Response to Planning application from Hertfordshire County Council (T and CP GDP Order 2015)

District ref: 6/2022/0863/FULL
HCC ref: WH/12344/2022
HCC received: 23 May 2022
Area manager: Matthew Armstrong
Case officer: Steven Knight

UNIT 13 PEARTREE FARM WELWYN GARDEN CITY AL7 3UW

Erection of detached two-storey brick building for B1 use with designated parking spaces for 6 vehicles and secure storage housing for 6 bicycles following demolition of existing timber building

ROOF PLAN - SEE DRAWING 08/603/25a
 Changes: Building slightly repositioned
 Two parking bays added.

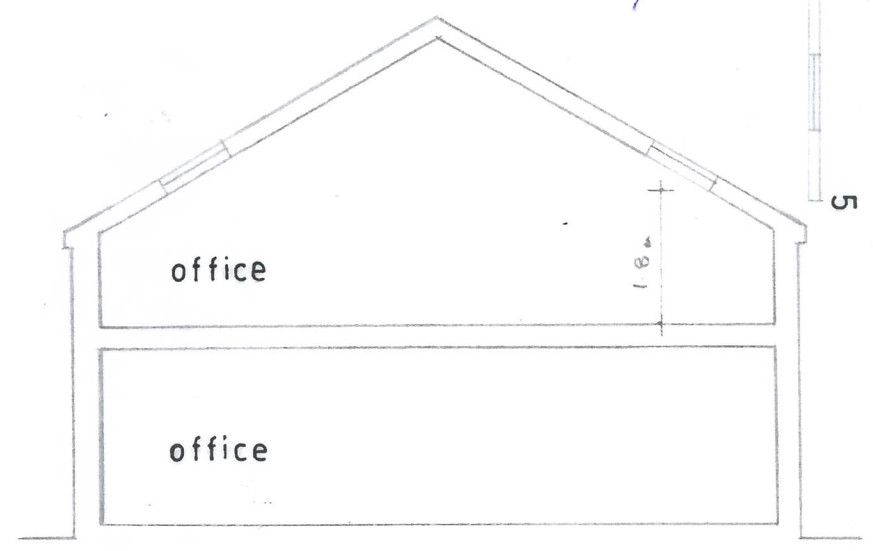
The site plan (drawing 08/603/25a) shows that six parking spaces will be provided as well as a loading bay. This provision is acceptable based on the LPA's parking standards and the site location within zone 2. It is also noted that secure cycle storage will be provided for six cycles which is also acceptable.
